Hunter Water Corporation  
ABN 46 228 513 446

Our Ref: HW2011-486/40/21

### **BOBS FARM SAND MINE PROJECT (SSD 6395)**

INDICATIVE CROSS SECTIONS
PROPOSE SAND MINE
NELSON BAY ROAD
BOBS FARM

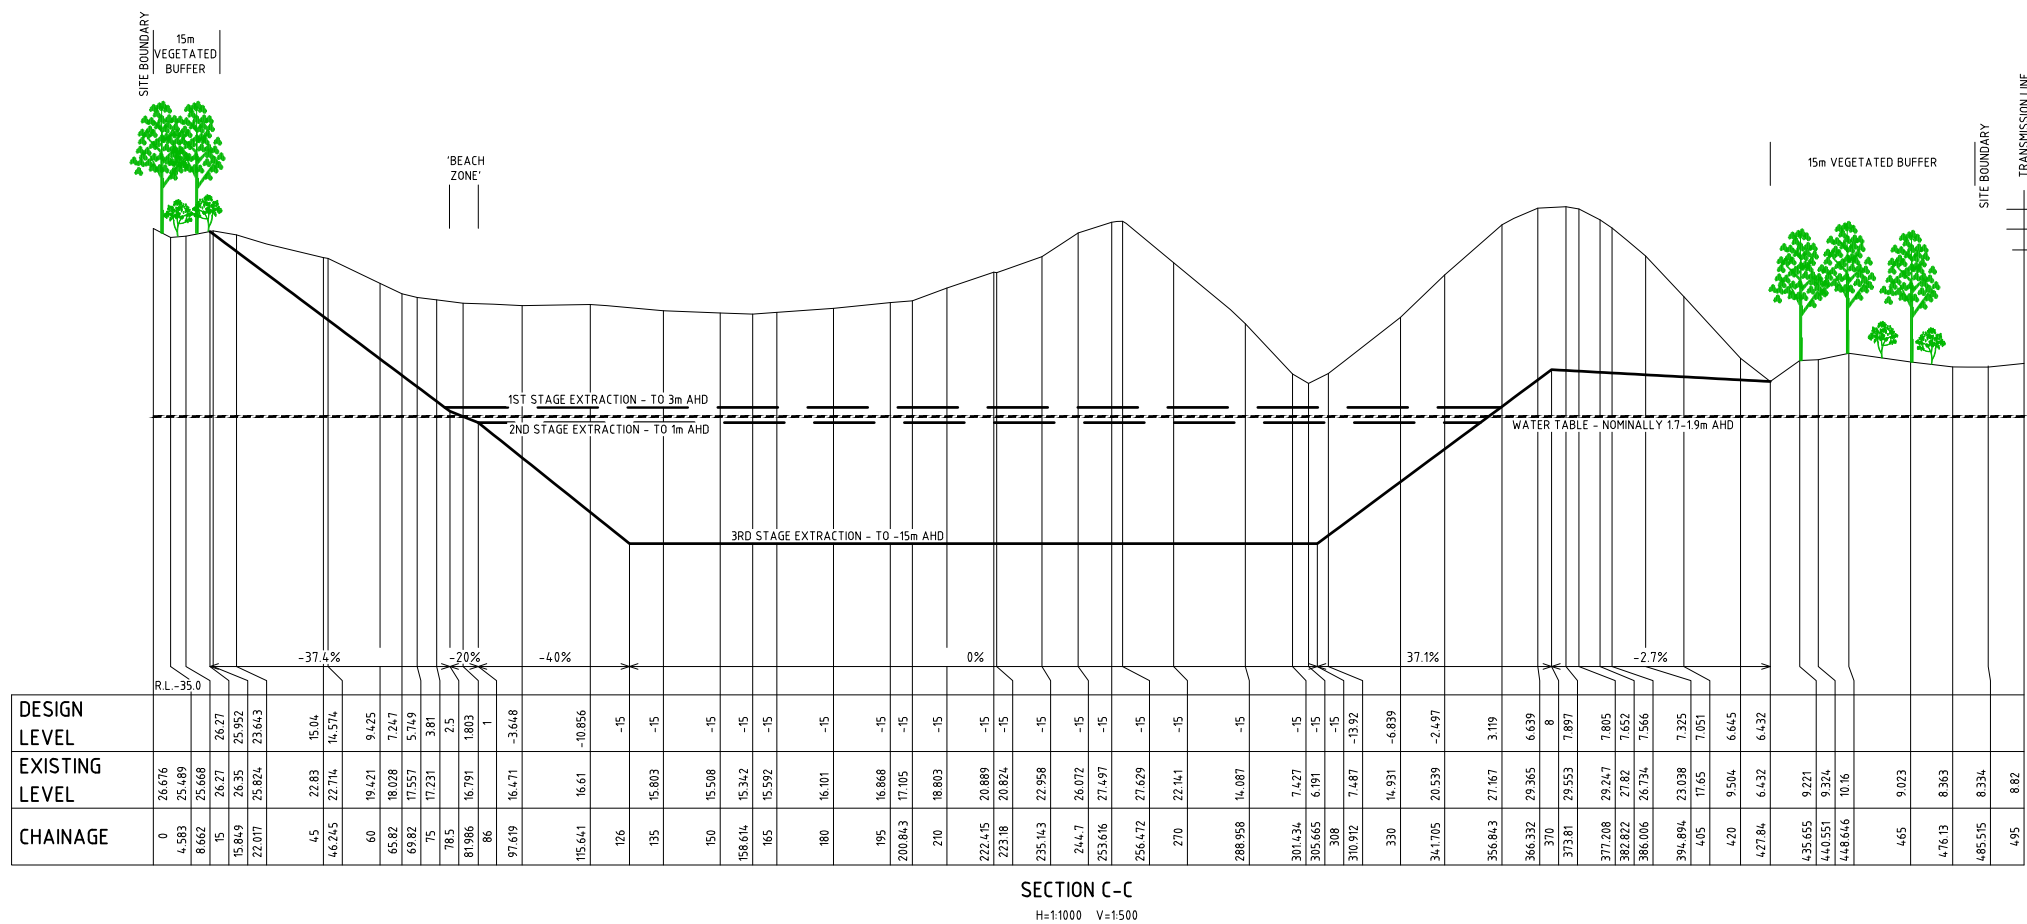
In regards to best management practice, we note that the proposal to extract sand below the water table to -15 metres AHD is inconsistent with current best practice and the approval of other sand extraction operations in the area, which have limits on the depth of extraction imposed upon them in order to protect groundwater sources. For example, sand extraction at Sibelco's Tanilba Northern Dune operation, Sibelco's Anna Bay operation, the Cabbage Tree Road Quarry (SSD-6125, yet to commence), Salt Ash Sand Quarry (07\_0094) and the Fullerton Cove Sand Quarry (07\_0145) all have extraction depth limits imposed upon them to safeguard groundwater sources. Measures to protect groundwater sources are related to both pollution risk and the loss of valuable water supplies through drainage and evaporation.

Hunter Water recommends that all extractive operations should be designed and undertaken in a way that ensures protection of water sources and facilitates sustainable future land use. Hunter Water is of the opinion that inadequate justification has been provided for the proposal to leave a 25 hectare open lake following the completion of sand extraction and it is simply a proposal to maximise the volume of sand extracted from the site and is not supported. The proposed extraction approach would not only result in ongoing loss of approximately 90 million litres of water per year from the aquifer through drainage and evaporation, but would, in the absence of a sound and approved proposal for a future water-based use of the site, result in a bad land use planning outcome that is not considered to be in the public interest.

Hunter Water considers that, with Port Stephens only a short distance away, the suggested future water-based uses for the site are implausible and without sound basis. Hunter Water therefore recommends that the dredging proposal not be approved. Instead, if extractive operations are approved, they should be limited in depth to protect the underlying groundwater source and so the site can be rehabilitated in a way that ensures a sustainable land use, compatible with the surrounding land.

Should the proposed activity be approved, limiting the depth of sand extraction to above the water table with a suitable buffer would be consistent with the determination of other sand extraction activities in the vicinity and is supported by Hunter Water. The approach adopted for other sand extraction operations in the area, where the extraction depth is limited by the requirement to create a final landform that is at least one metre above the predicted maximum groundwater elevation, is considered suitable.
